**WEST SUSSEX COUNTY COUNCIL
INFRASTRUCTURE CONSULTATION**

SUBJECT: A/133/09/A- One internally illuminated box sign.

Angmering Manor Hotel, High Street, Angmering, West Sussex, BN16 4AG

32 LOXWOOD AVENUE, WORTHING, WEST SUSSEX, BN14 7RA Tel: 01903 212680 Fax: 01903 239001 or Tel/Fax 01273 580733			
Project			
ANGMERING MANOR, ANGMERING			
Title			
PROPOSED 'AA' GUEST ACCOMMODATION ILLUMINATED SIGN			
Date	Scale	Drawing No.	Revision
Nov. 2009	1:20	968/09

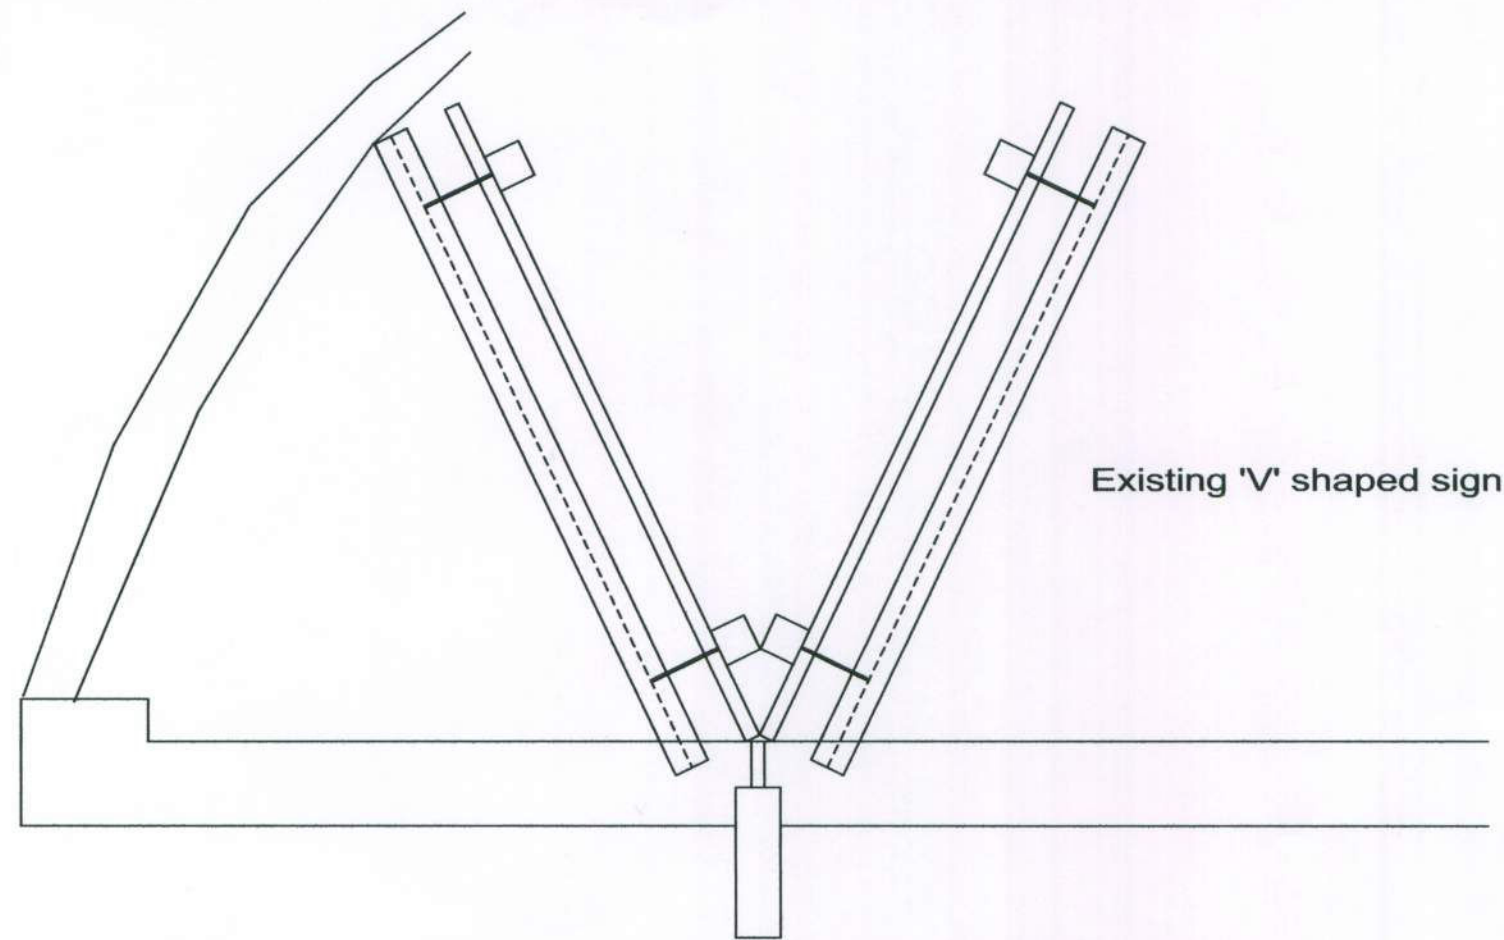
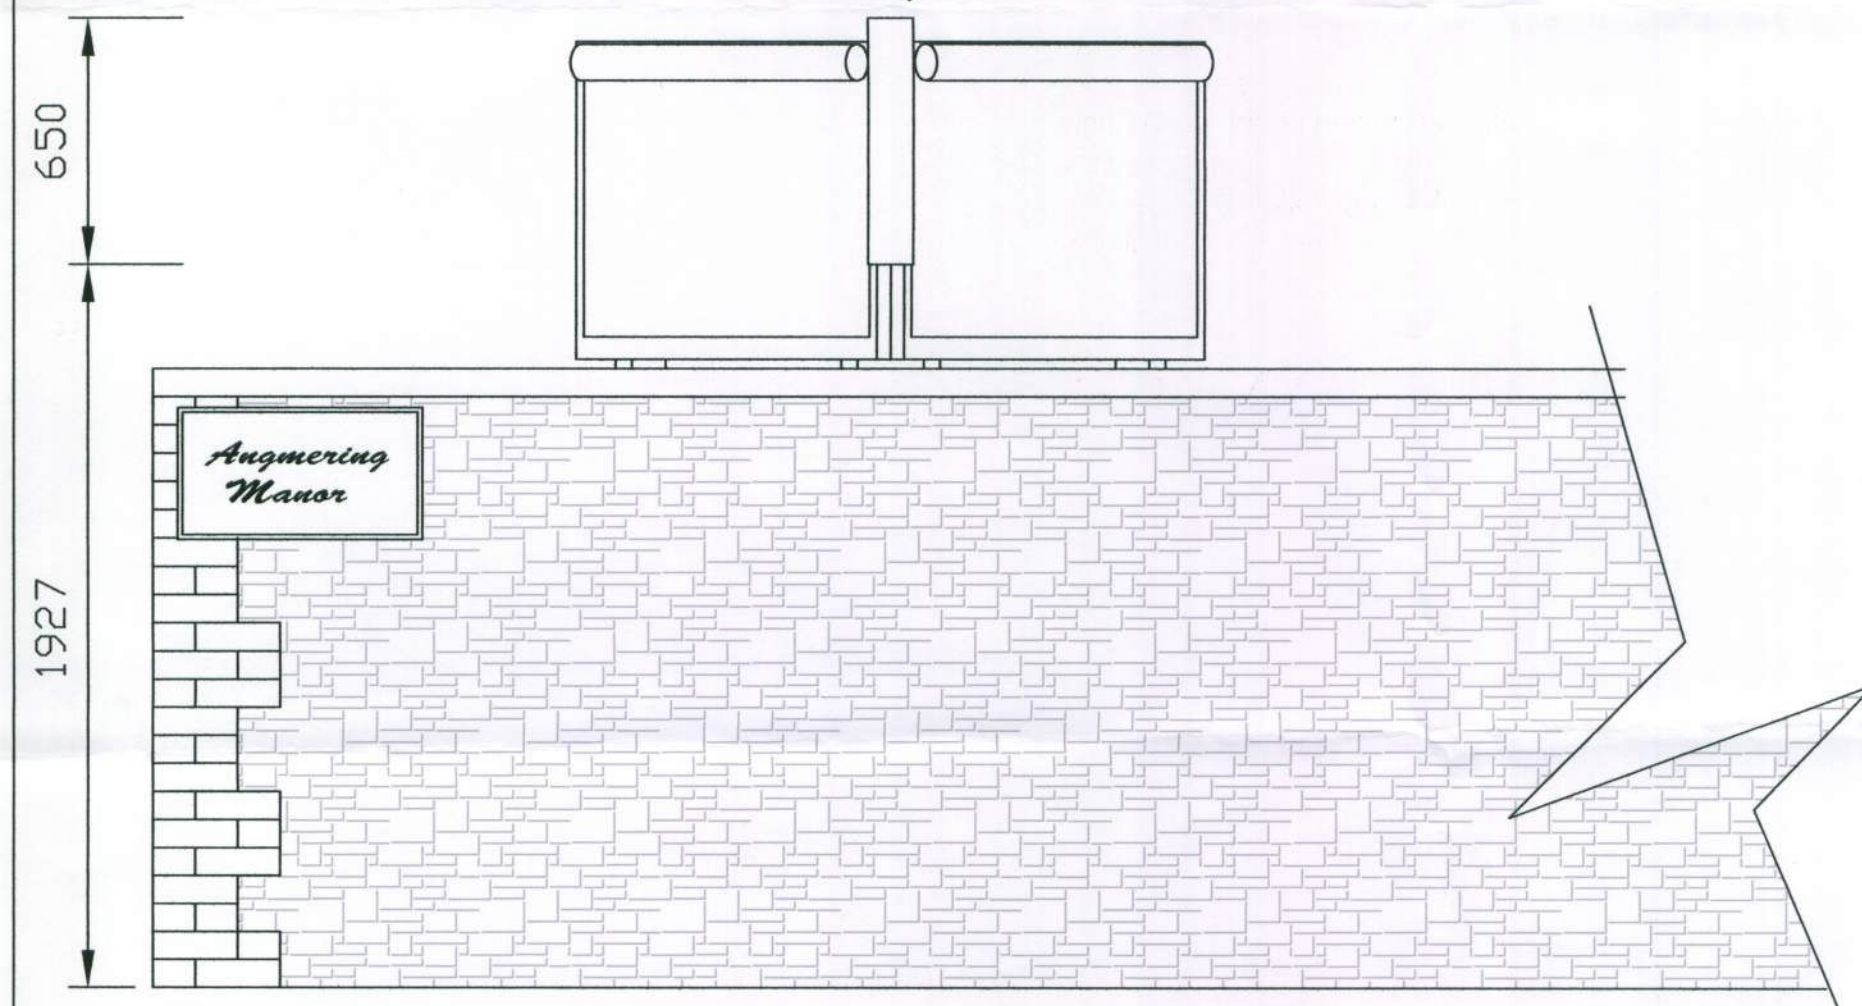
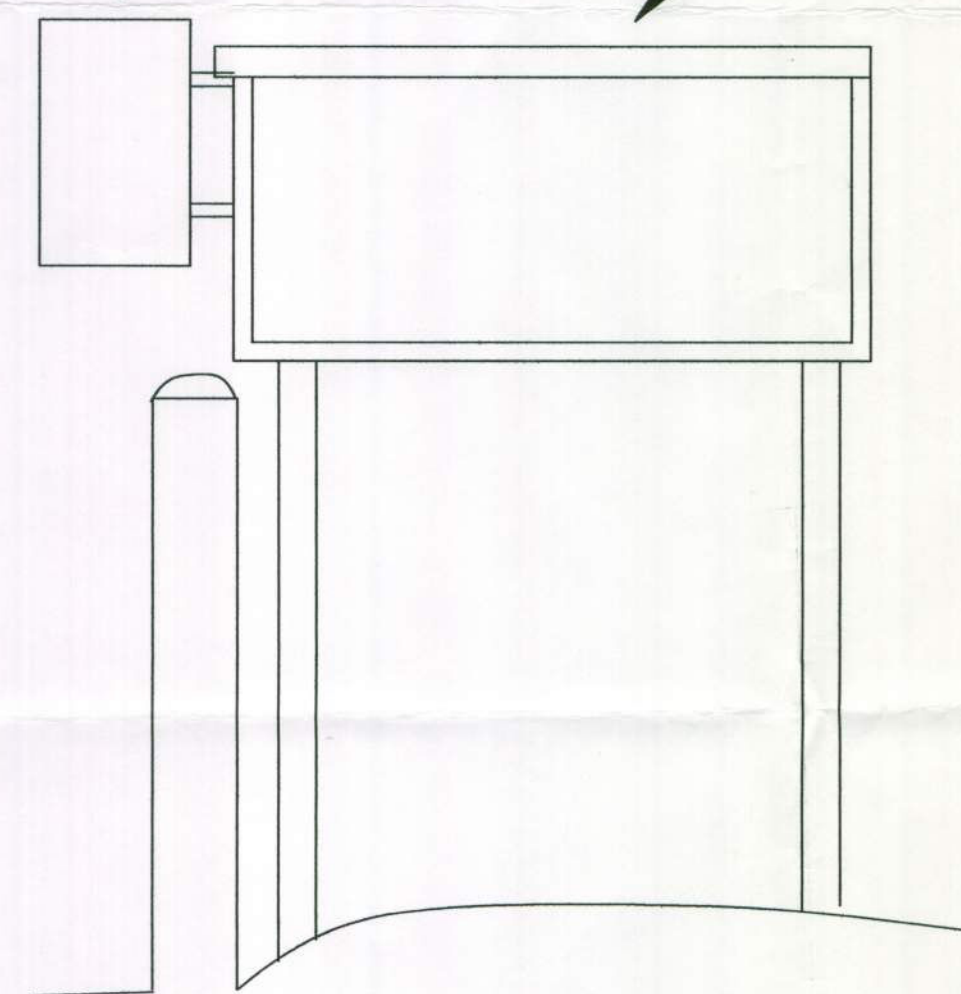
Upon inspection of the plans, it does not appear that this illuminated box sign is in a location where it could obstruct the highway. From an inspection of the plans it would appear that the sign overhangs the pavement, therefore a Highway license will be required before it is erected. Provisionally, there would be no highway objection to this sign, providing its luminance levels do not exceed 1000 cd/m² and a licence is acquired from WSCC.

Before the commencement of any operation, the applicant is advised to contact West Sussex County Council (Tel no: 01243 642105) to obtain a Section 177 Licence under the Highways Act 1980 to cover any structure that overhangs the highway.
